4.3 Jones Bay Road F&B Tenancy

4.4 Revised Ritz Carlton to Star Resort links

4.5 Car Stacker

title
**General Arrangement Plans
 B5 Floor Plan**

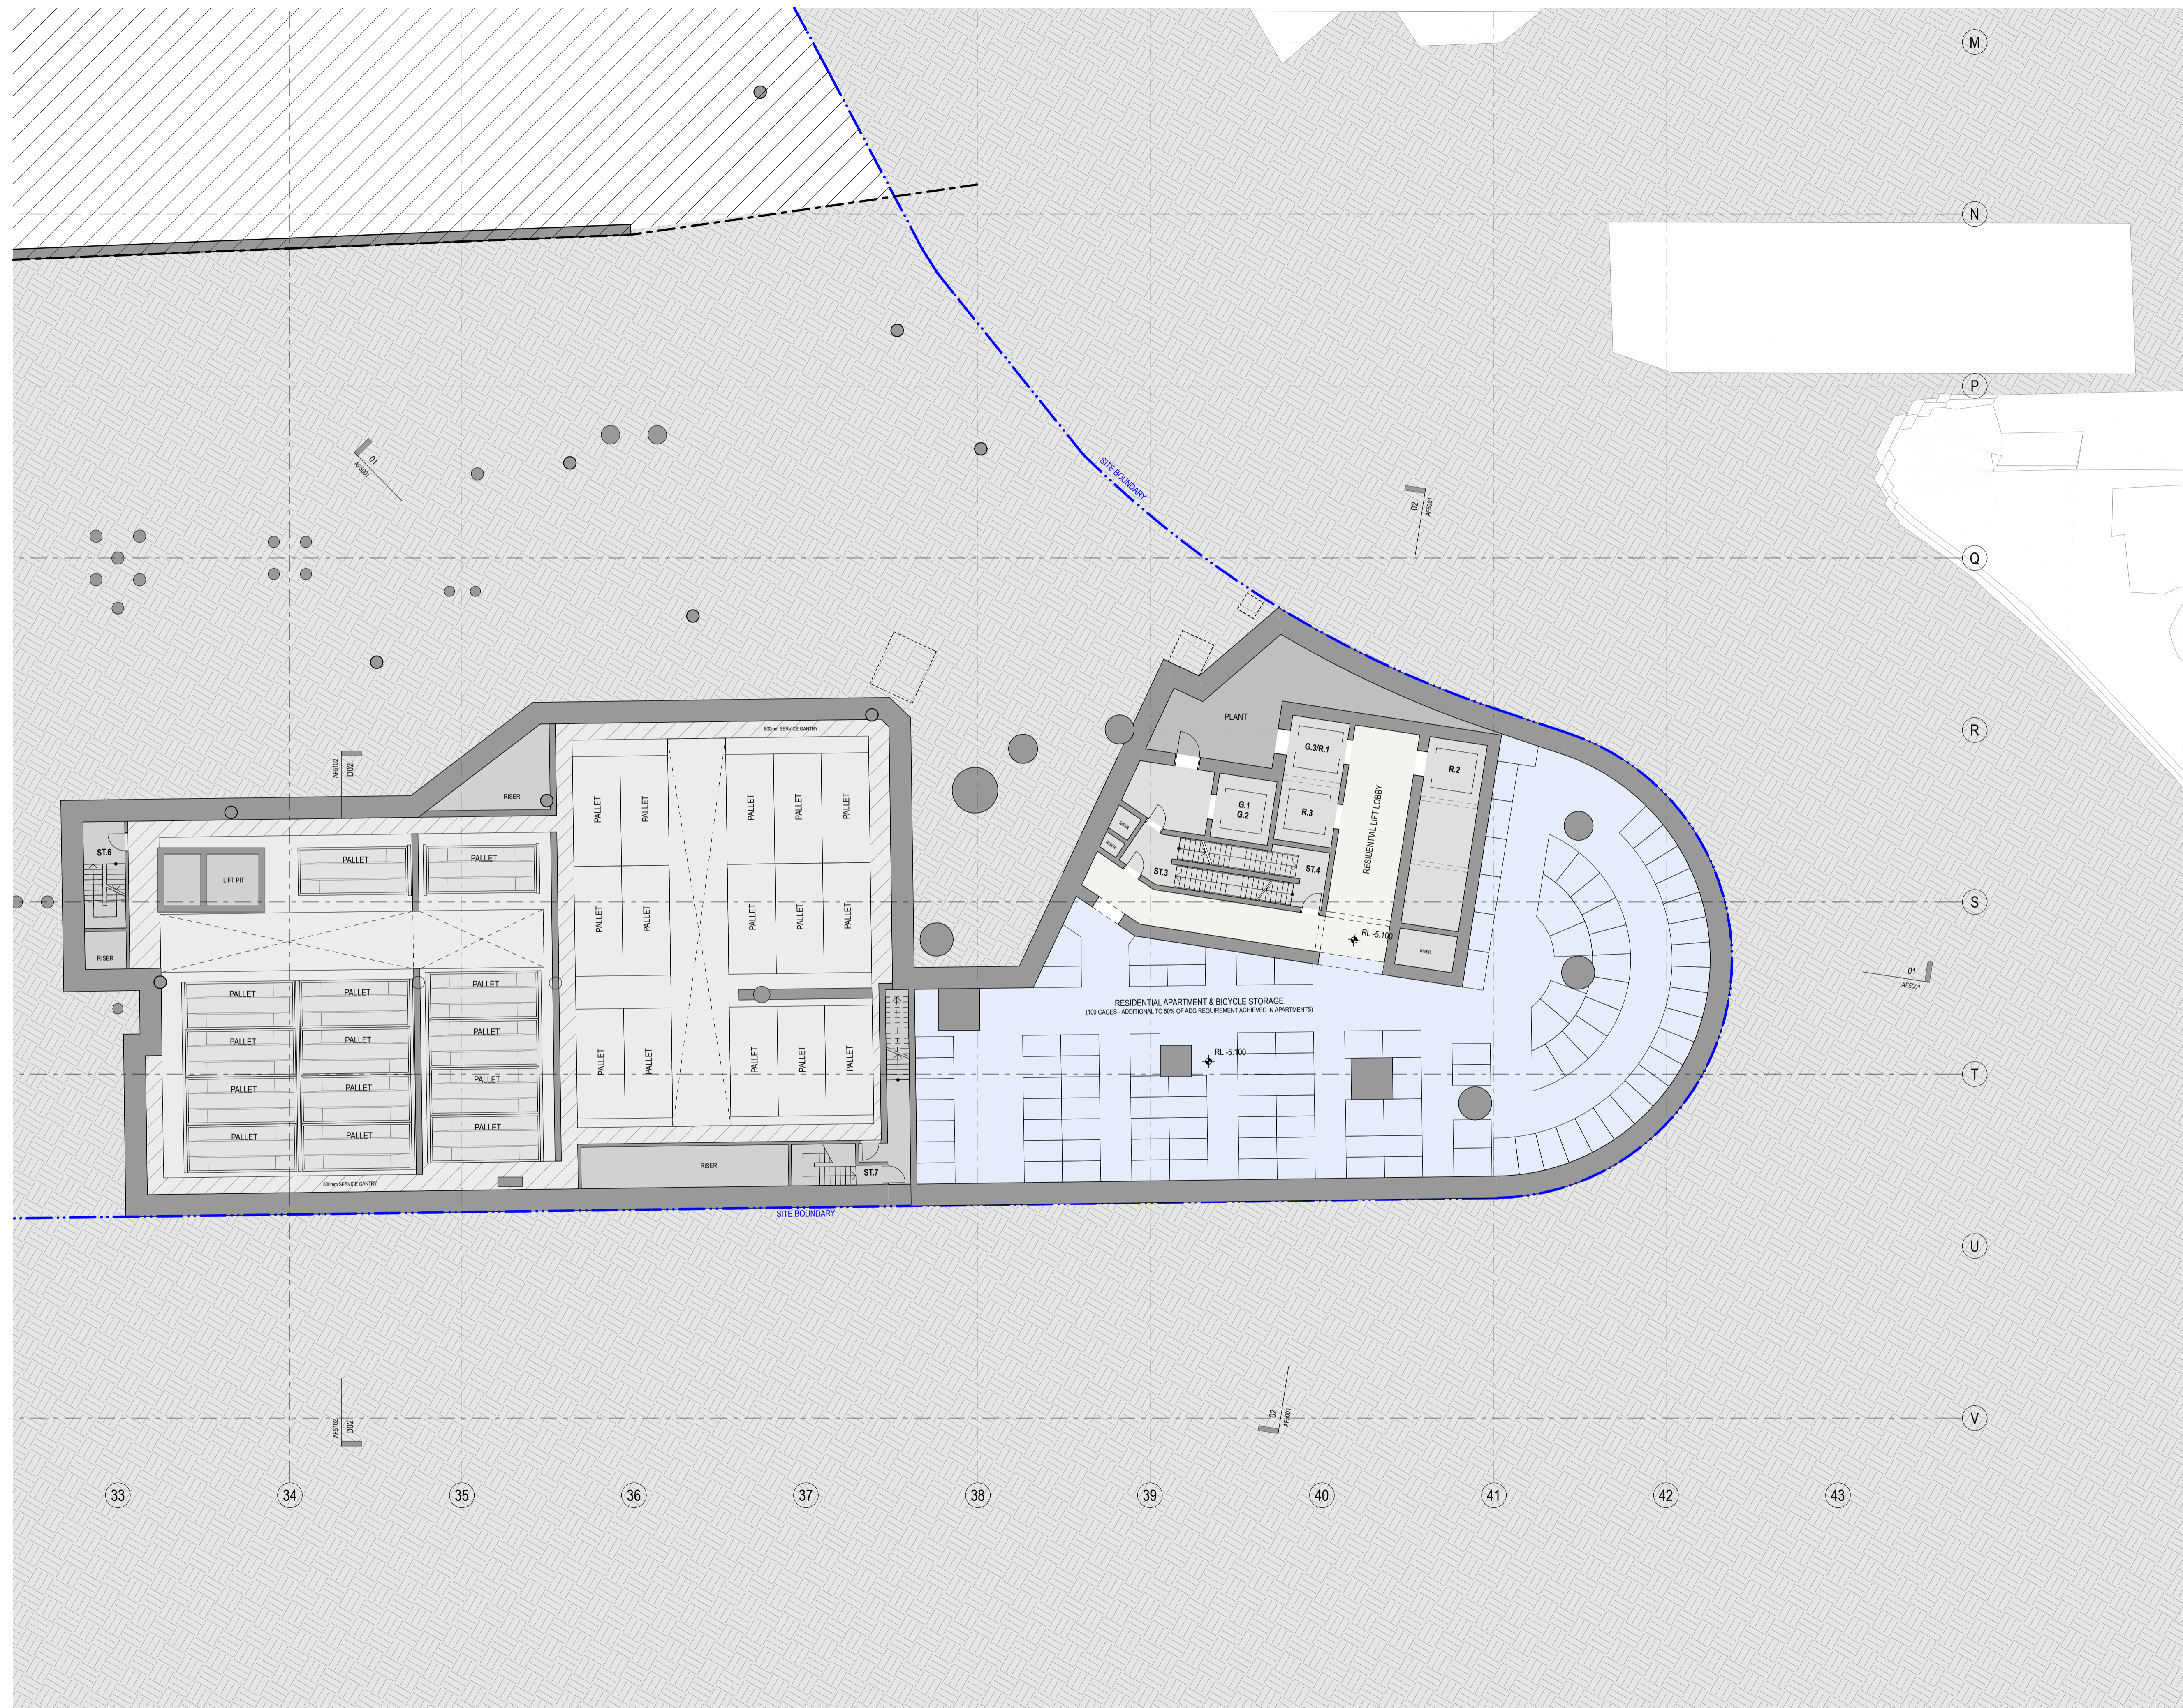
Continued development of the car stacker and basement envelope since formal lodgement has resulted in improved efficiencies with a reduction of basement excavation of two levels.

The revised plan (right) highlights the updated basement envelope with removal of existing legacy structure and increased capacity of system 1. This update has also captured an additional egress stair allowing 2 points of egress for access and fire fighting purposes.

Revised AF201 B5 Floor Plan - with updated efficient car stacker layout

Jones Bay Road Street Elevation

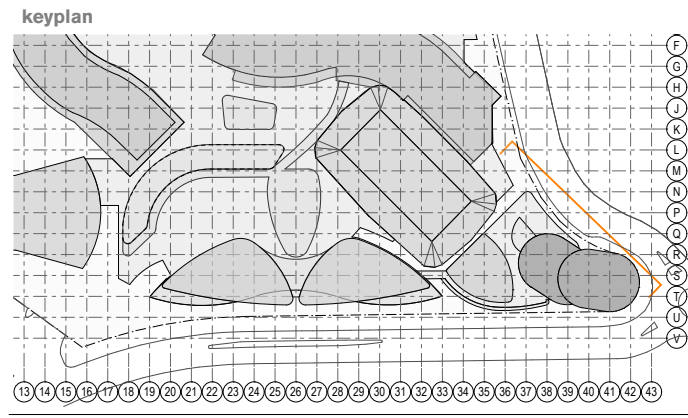
Proposed as a VIP access from the Hotel tower core at L04 mezzanine, this link snaked along the Jones Bay Road facade as a new glass insertion. Length of travel, complications with fire rating and materials, plant room configuration at L04 and the creation of the Ritz Carlton lobby to L00 access has contributed to a reduced viability for this VIP path.

An elevation comparison of Jones Bay Road is shown (right). The revised elevation shows the removal of the glass link, and improved condition for neighbouring residents along Jones Bay Road.

Revised AF4102 Jones Bay Road Elevation

title  
**General Arrangement Plans  
Level 04 + 04 Mezz Floor Plan**

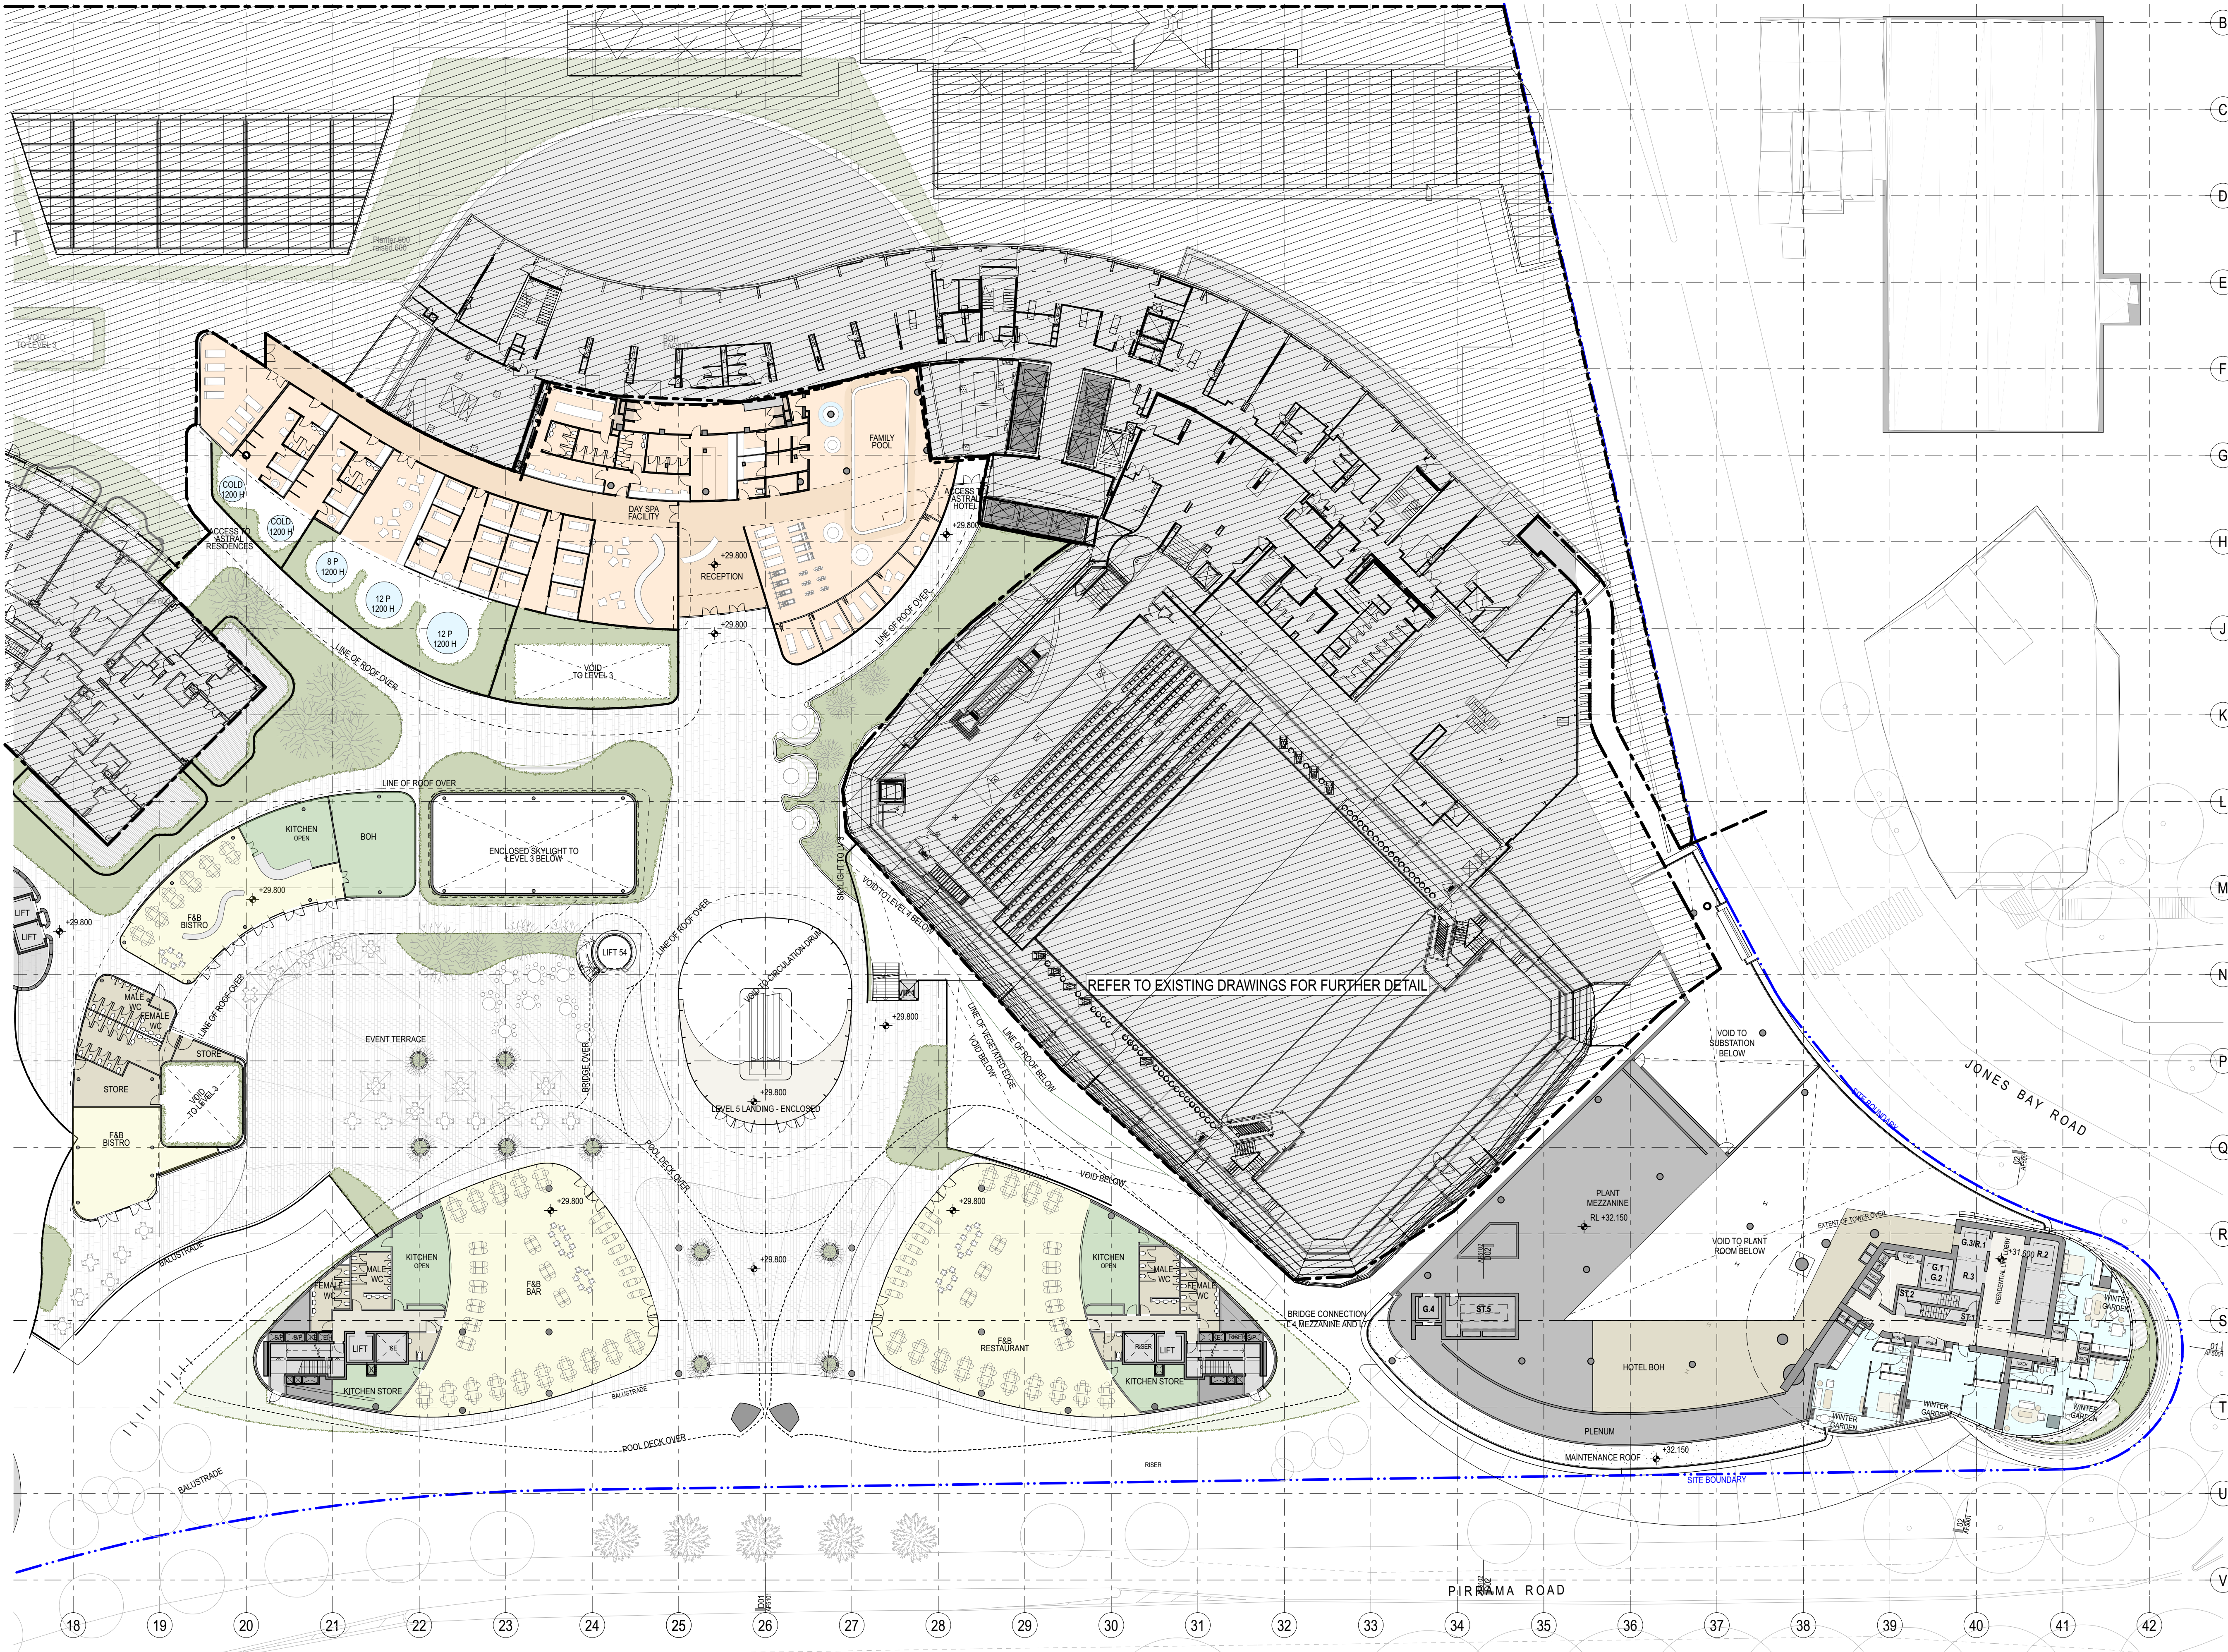
The second redundant link was designated at L04 and transitioned through the North F&B tenancy proposed in MOD 14 (shown right top). This resulted in reductions to head height and clearances to the tenancy and complications with a proposed plant room adjacent to the core, stair and associated service rises. This link has been removed to simplify access paths and tenancy conditions as proposed in MOD 14.

Revised AF1004 Level 04 + Level 04 Mezz Floor Plan - without VIP link
